CITY OF ALBUQUERQUE

**RE: Arroyo Vista Median Swale
Grading and Drainage Plans
Engineer's Stamp Date: 06/6/19
Hydrology File: J08D005, CPN 651182**

Comments on Submittal:

ARROYO VISTA MEDIAN SWALE
(INTERIM CONDITION WITH
ONLY NORTH SIDE OF
ROADWAY BUILT)

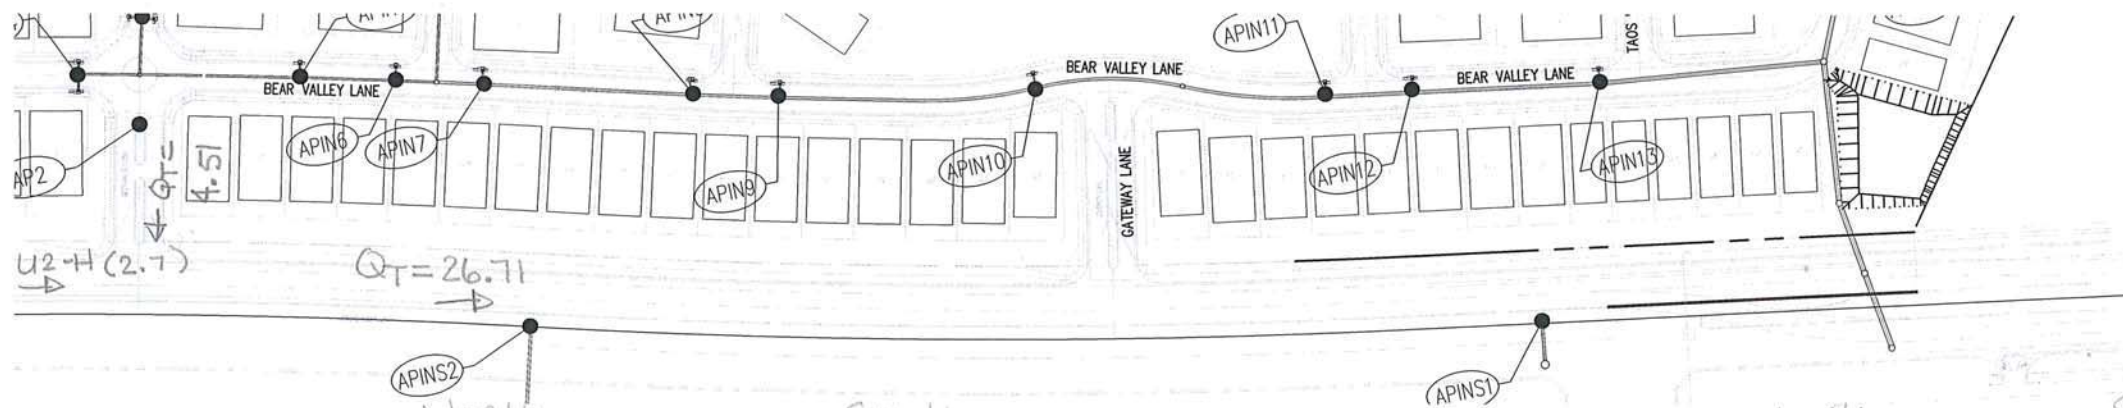
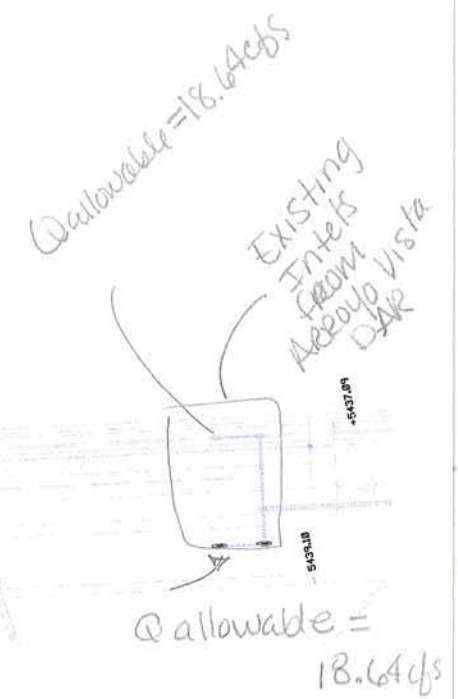
3. Update the calculations for the inlet at the east end of the swale with the revised flow rate.
4. For Basin OS-1, move/point the flow arrow so that it is clear that this basin drains to the arroyo located south of the Arroyo Vista Blvd ROW.

INSPIRATION SUBDIVISION
PROPOSED BASINS MAP

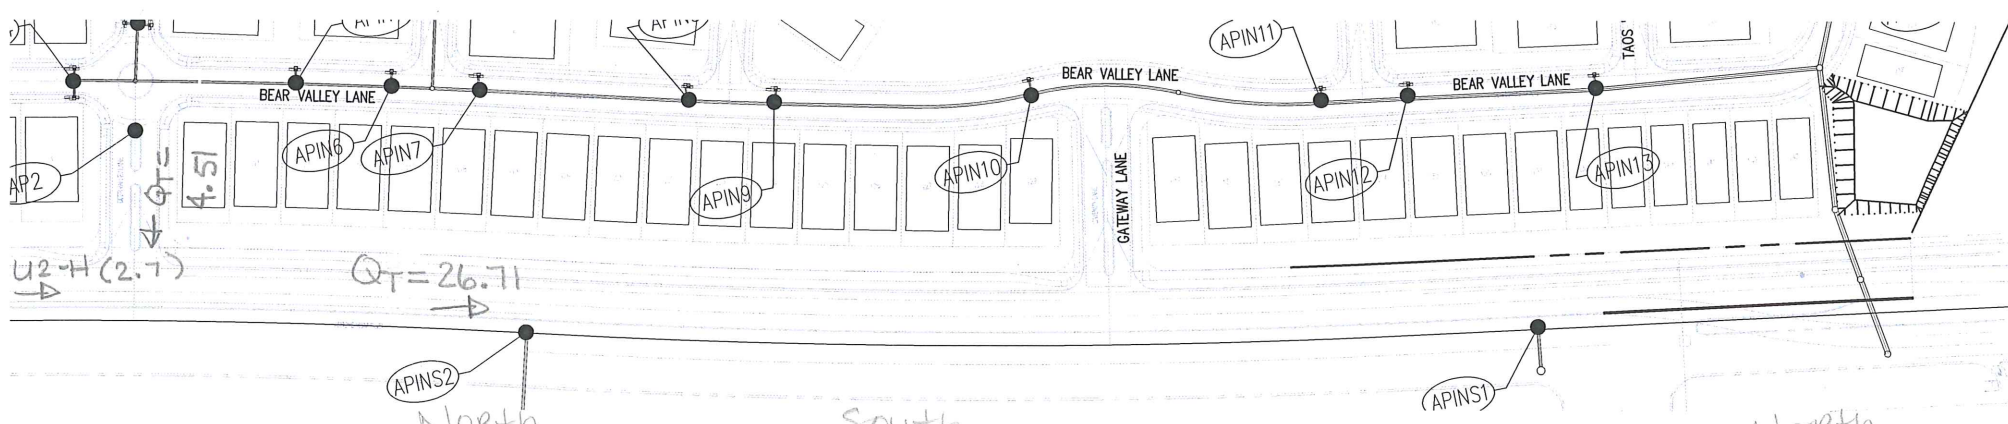
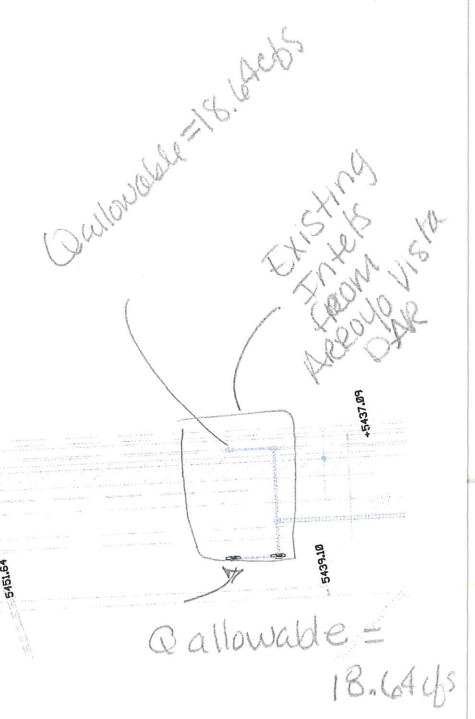
It appears the drainage from Basins OS-1 and OS-2 contributed to the damage and overtopping of the median curb in Arroyo Vista Blvd.

1. Per the DPM Figure 6.9.9, the capacity of a double inlet at 0.7' of depth at 0.2% slope is 10 cfs. The submittal states there is 29 cfs. The inlet appears to be undersized. The city does not count the 'throat' for its inlet capacity as it is there in case the grate plugs, which happened during the storm event referenced above.
2. From a site visit it appears that 2/3 or so of Basin OS-2 drains to Basin U2-H before entering Arroyo Vista Blvd ROW. Grades were altered during wall construction, so existing grades cannot be used. In addition, the land was driven/worked on. Please update the basin calcs to 2/3 of 1.36 acres= 0.9 acres and use 100% Type C land treatment. In addition, Basin OS-2 should be broken up into two basins as there are two outfall locations. This would also allow for an "Arrow" showing the outfall location through Basin U2-H.
